Please scan as additional and substitute information

I am contacting you in regards to the development at Toddington Lane (LU/162/17/PL) and condition 14. In your comments on 15th October 2019 you asked for A visibility splay of 2.0m * 66m in both directions at the western end of the proposed footway. This was to ensure any pedestrians crossing in this location have sufficient visibility to see any oncoming cars. The 66m visibility splay is achievable looking west but not looking east.

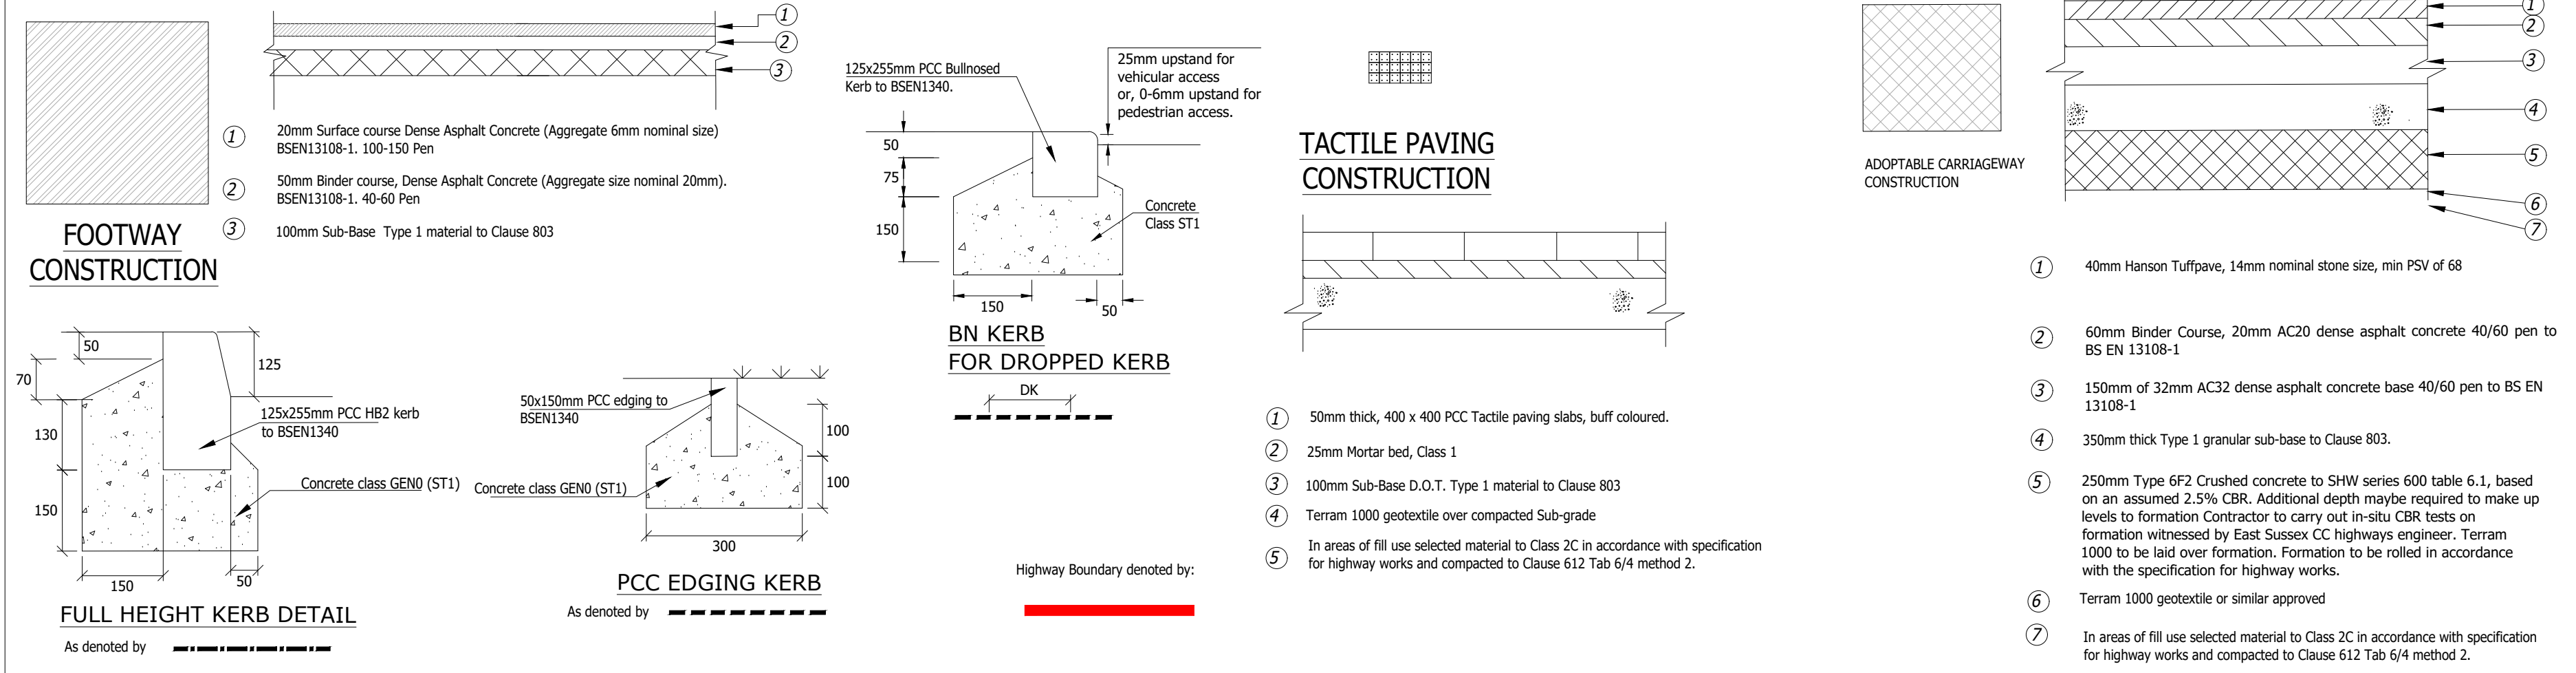
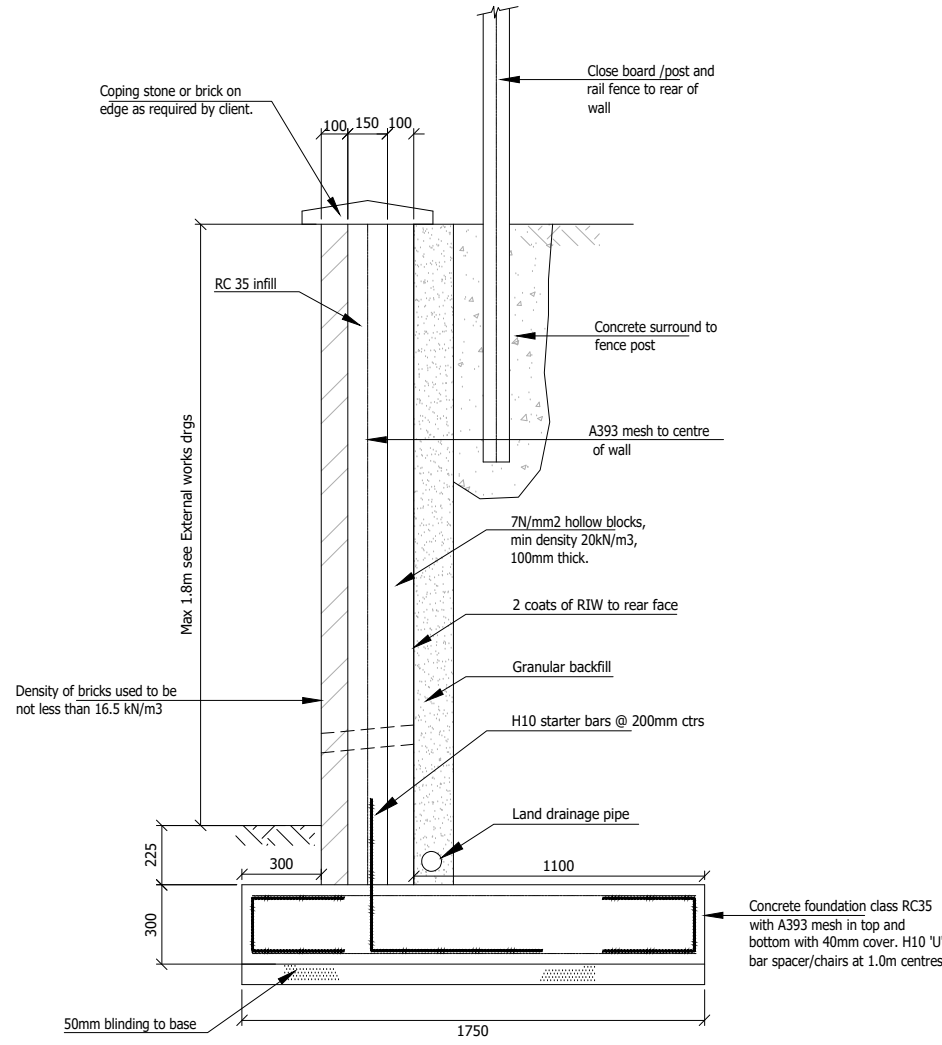
We have had a speed survey completed on Toddington Lane to assess if the 30mph speed limit you based the visibility splay on was accurate to the actual speeds. Please see the ATC data attached. The ATC indicates that the mean speed for westbound traffic is 24mph and the 85%ile speed is 28mph (7 day mean). It should be noted that the position of the ATC was further to the west than the position of the proposed crossing and is likely in a location where vehicles are accelerating out of the corner. The vehicles speeds at the proposed crossing point are actually likely to be lower than 28mph.

I note that section 4 of WSCC design guide states that lightly trafficked residential roads have 85%ile speeds below 37mph, can have MfS1 standards applied. As this is the case for Toddington Lane, the 66m visibility splay is likely in excess of the stopping sight distance for westbound vehicles will need to see pedestrians. Using MfS1 standards and the recorded 28mph 85%ile speed there is a stopping sight distance requirement of 39m.

I also note that the visibility splay asked for is from 2.0m, the proposed footway is 2m in width and it is unlikely a pedestrian would be stood on the back edge of the footway, would a visibility splay from 1.0m be acceptable as this is likely to be more reflective of a pedestrians position on the footway.

With the above in mind I would suggest a 1.0m * 39m visibility splay should be acceptable and allow for the crossing point to function safely. Please see update site layout with the visibility splays, I have shown 66m looking westwards as this is achievable and 39m is achievable looking east. Please note I have shown the 39m visibility splay to 600mm off of the kerb to represent the likely position of a car.
